CITY OF PORTLAND, MAINE
HISTORIC PRESERVATION BOARD

June 21, 2013

Re: Storefront Alterations; 15 Exchange Street

SWAP #1 &
#2 FRONTS

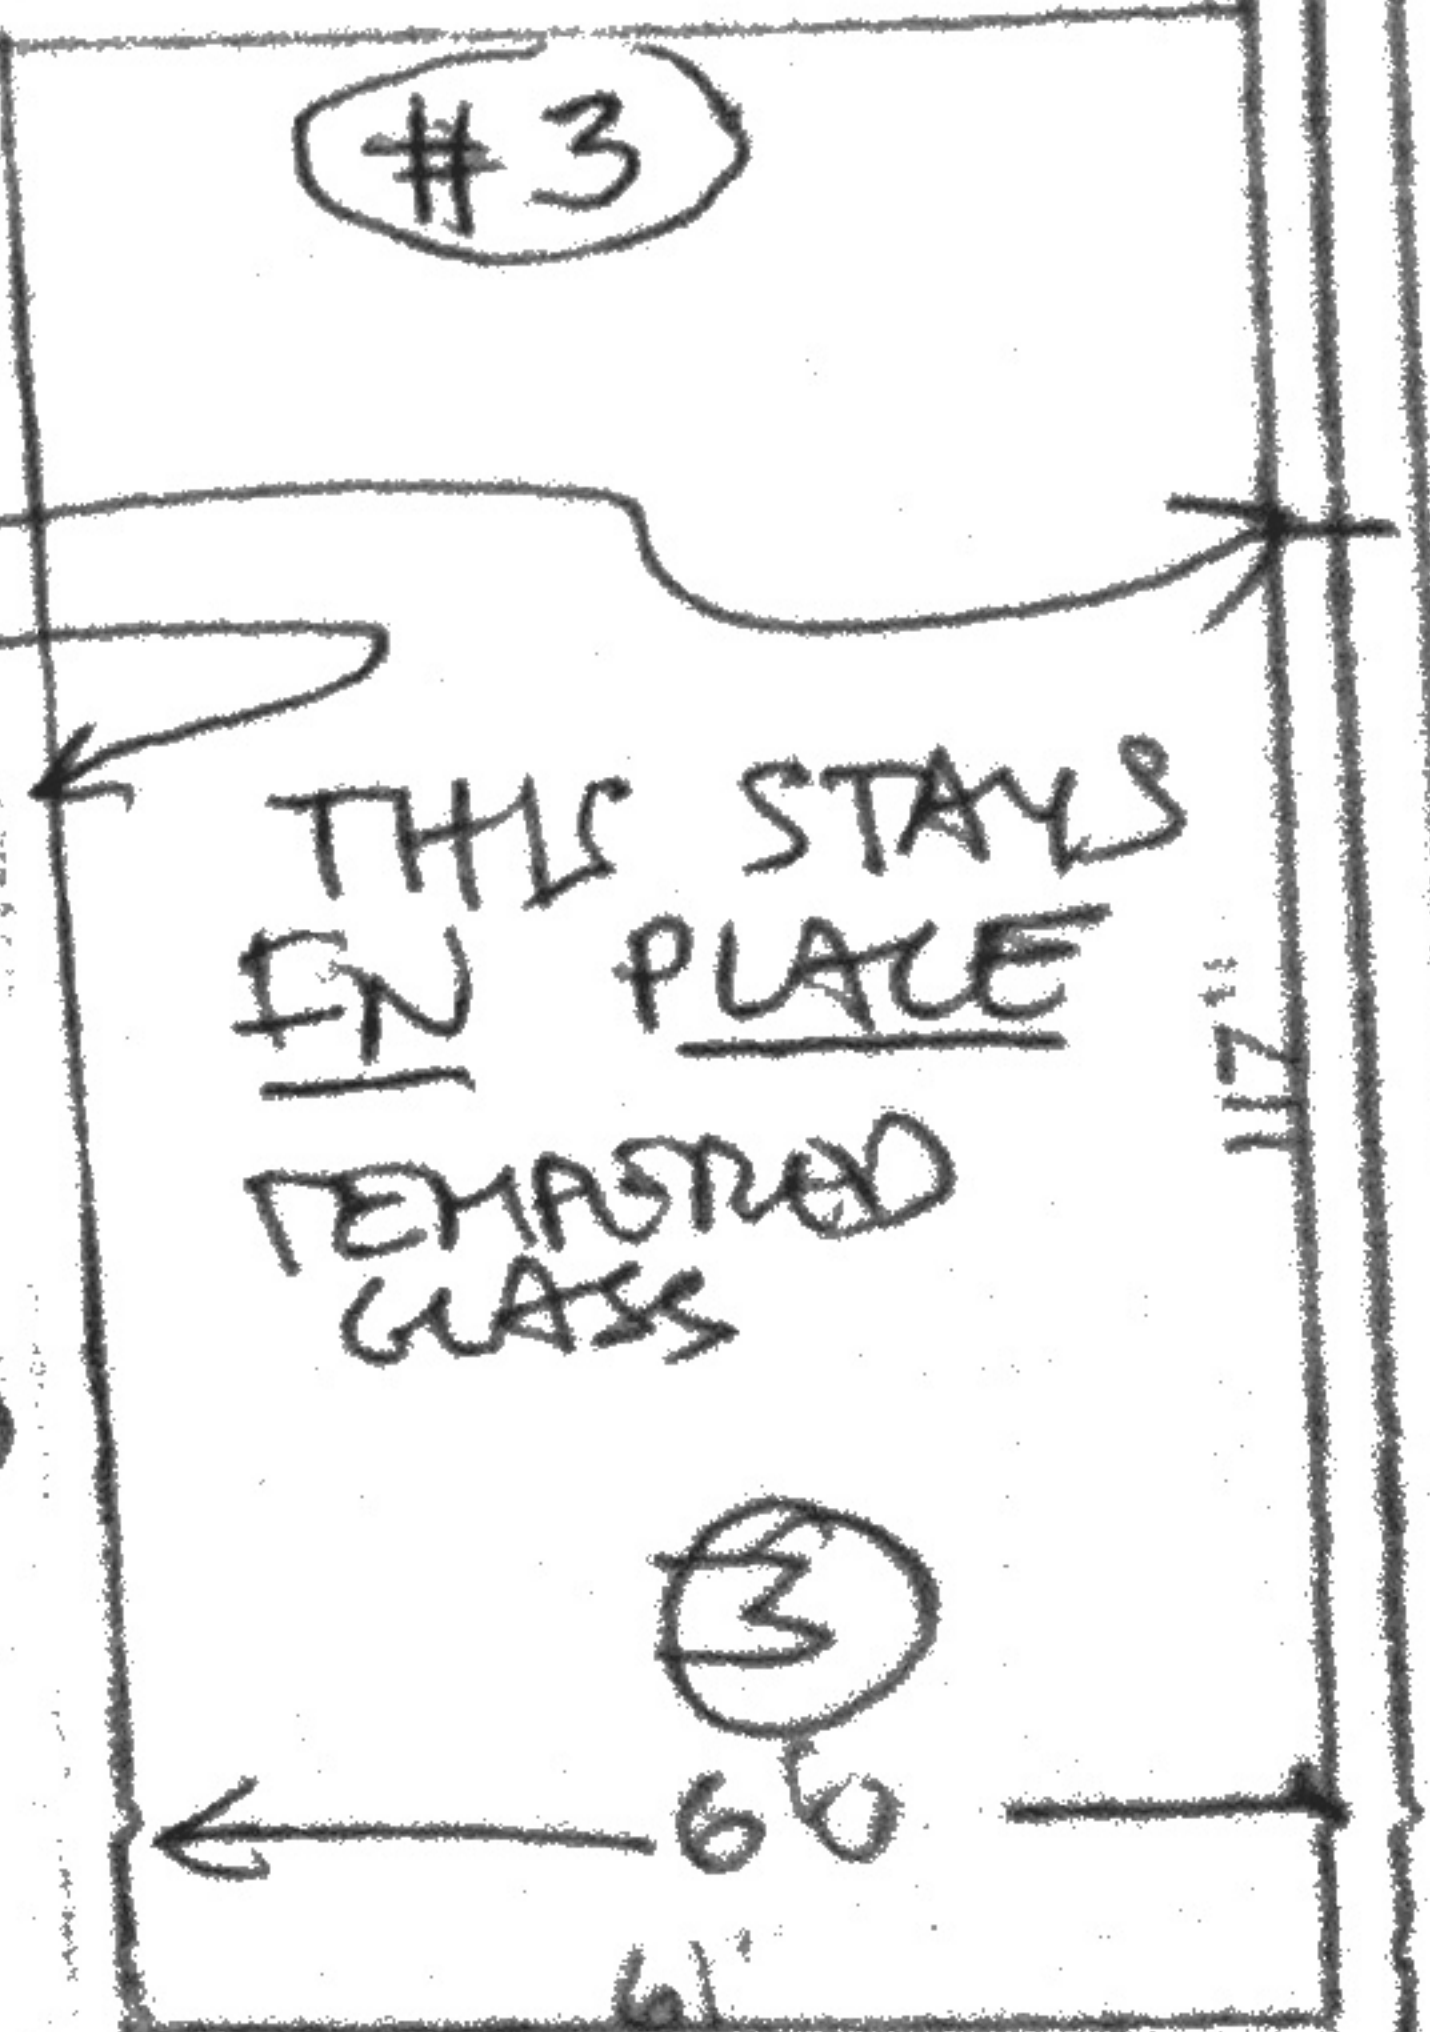
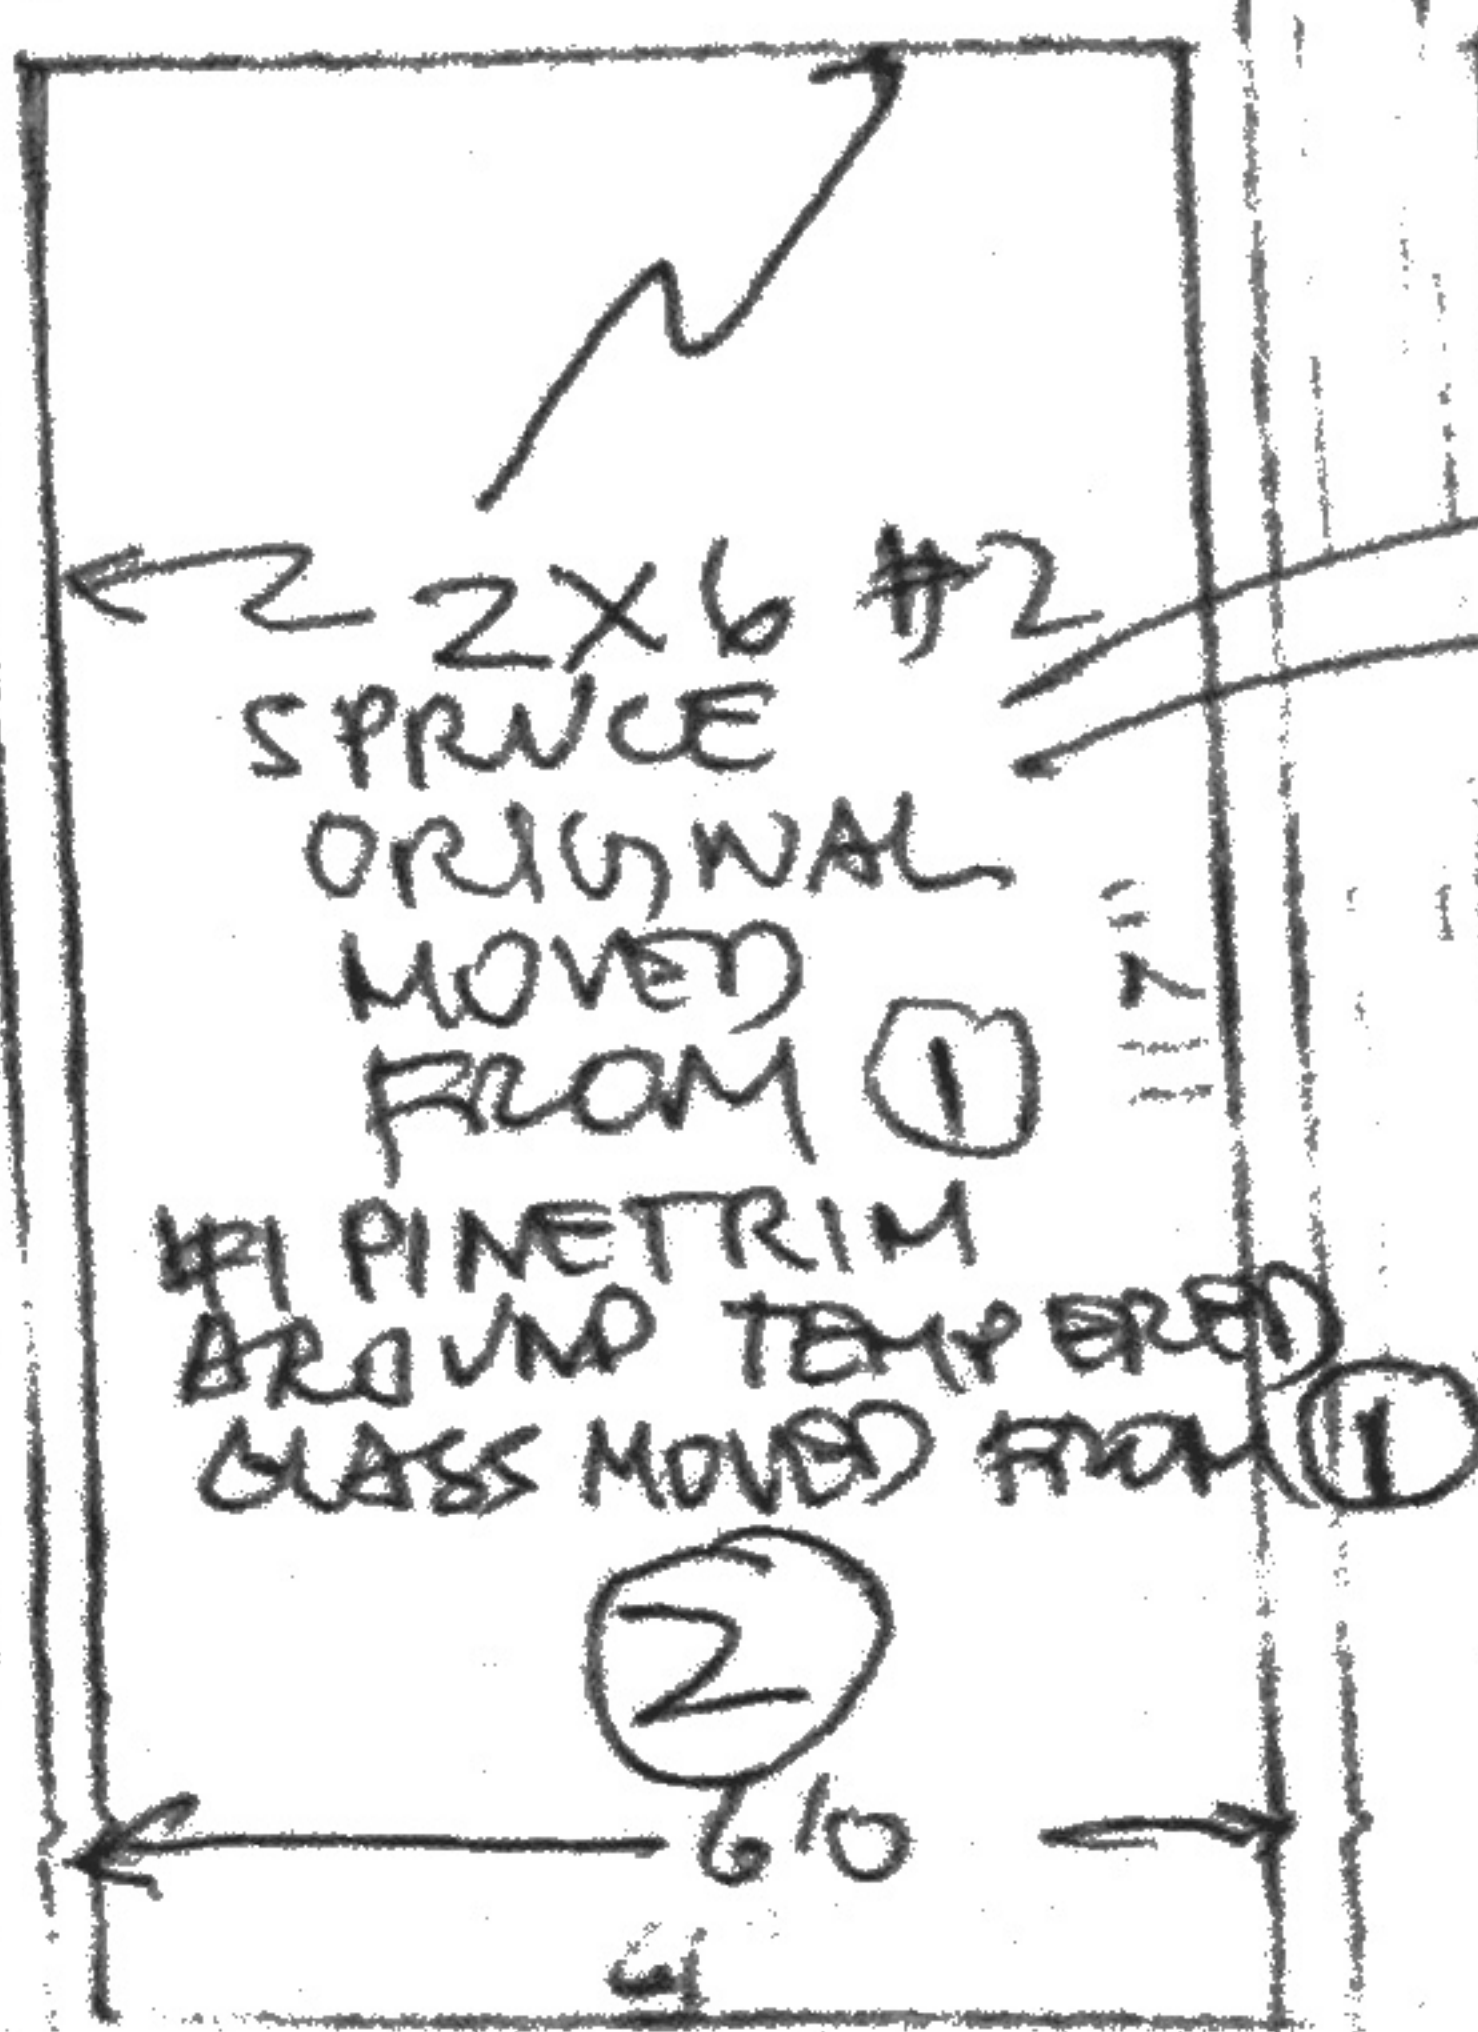
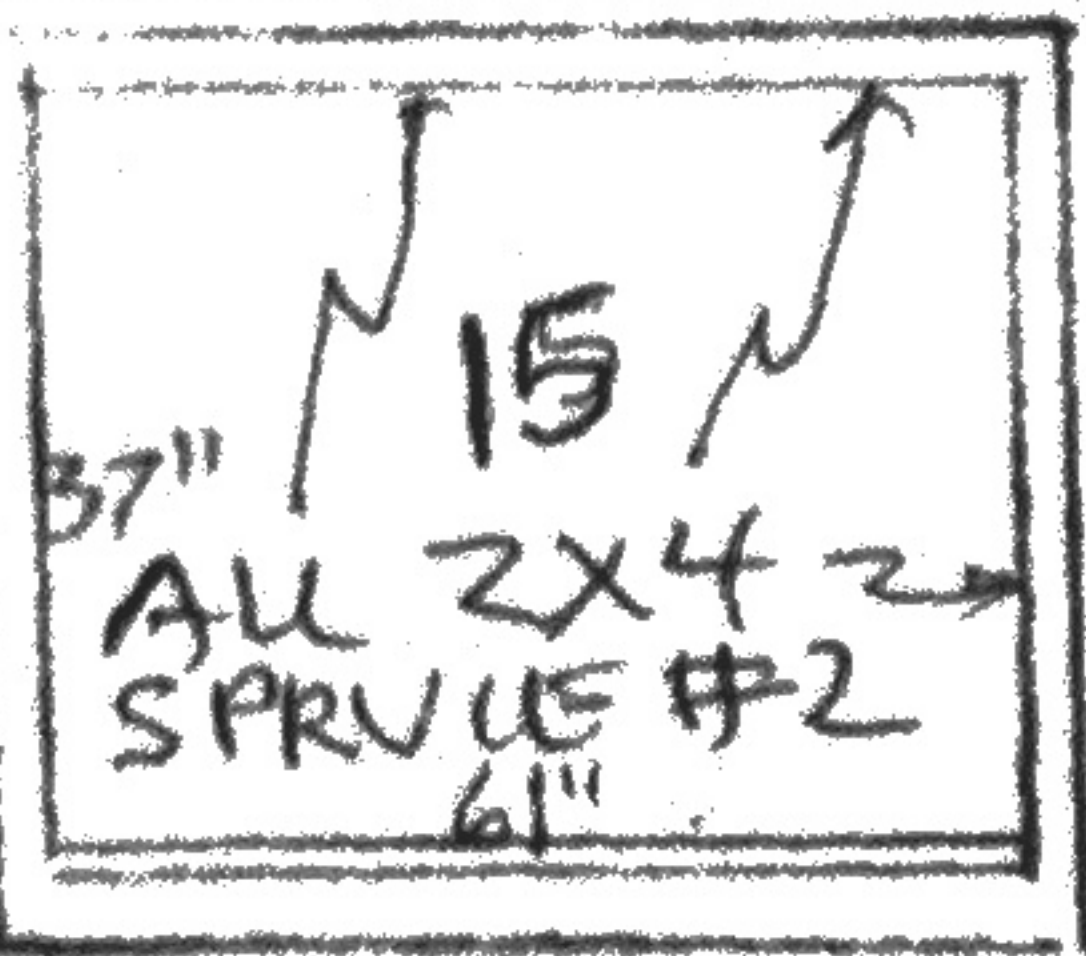
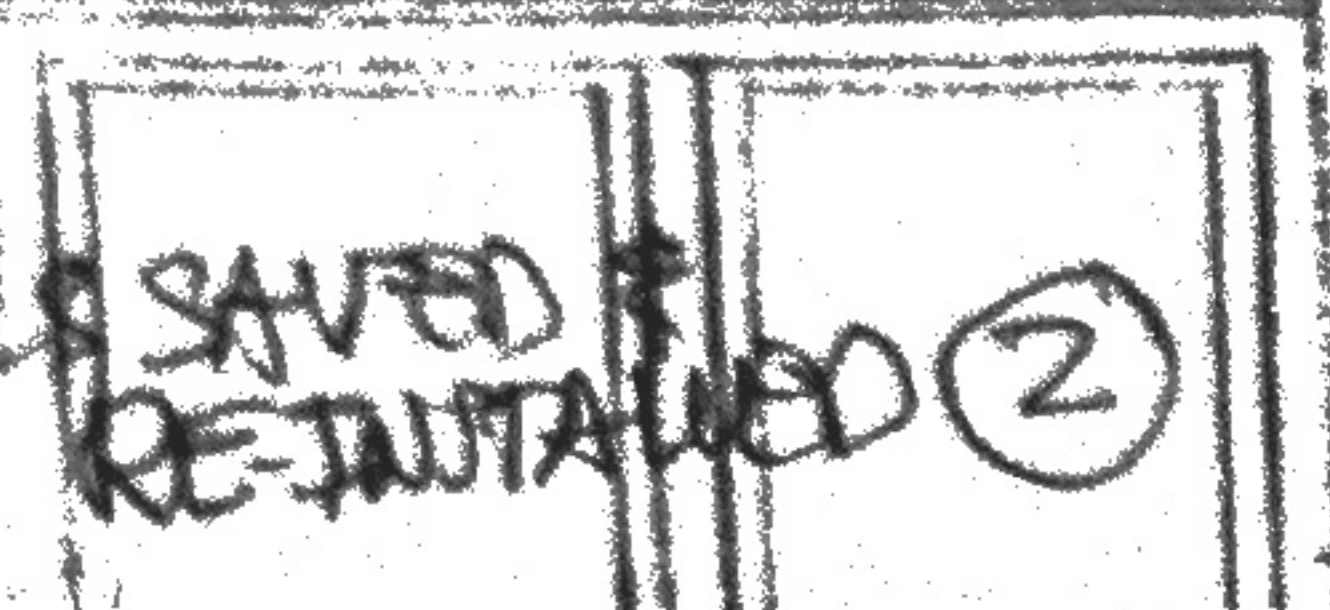
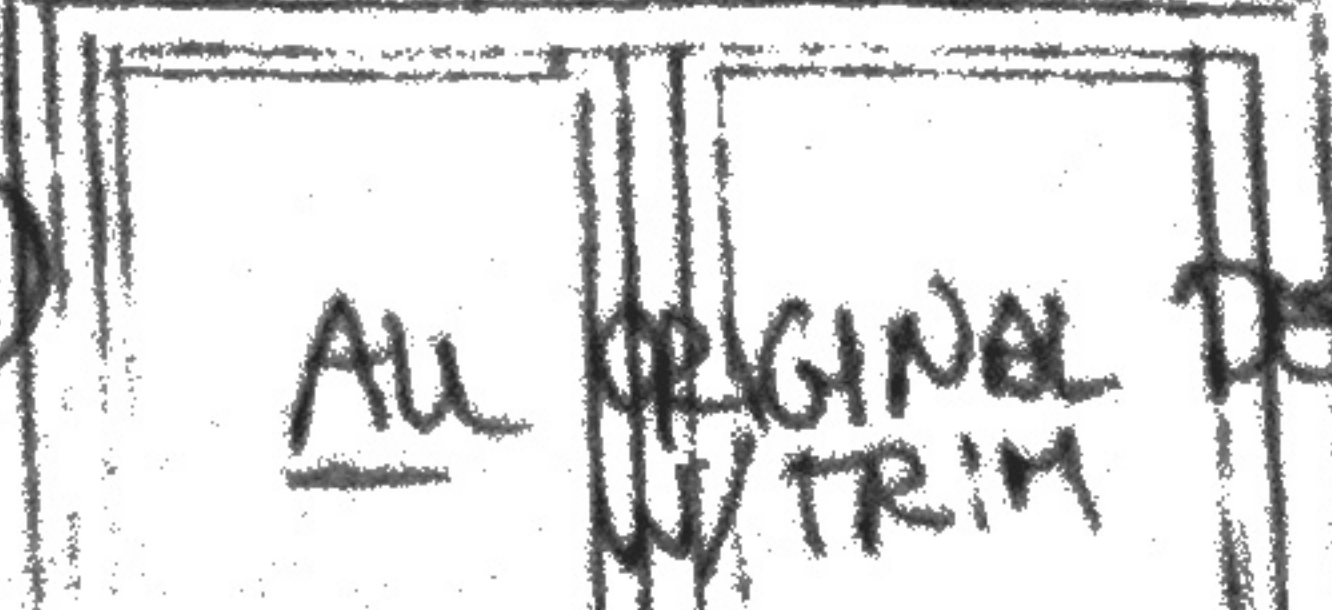
- All trim profiles and frame details to match details of remaining unaltered storefront bay.
- Final finish material and construction details of entrance threshold to be reviewed and approved by HP staff. (The Board recommends installation of granite or tile, consistent with threshold surface materials in the vicinity)
- Any additional lighting to be reviewed and approved by HP staff. Existing floodlights mounted on cast iron columns to be removed.
- Applicant to arrange for series of mid-construction inspections to ensure conformance with conditions and quality workmanship. (Call Rob Wiener, Preservation Compliance Coordinator, at 756-8023.)
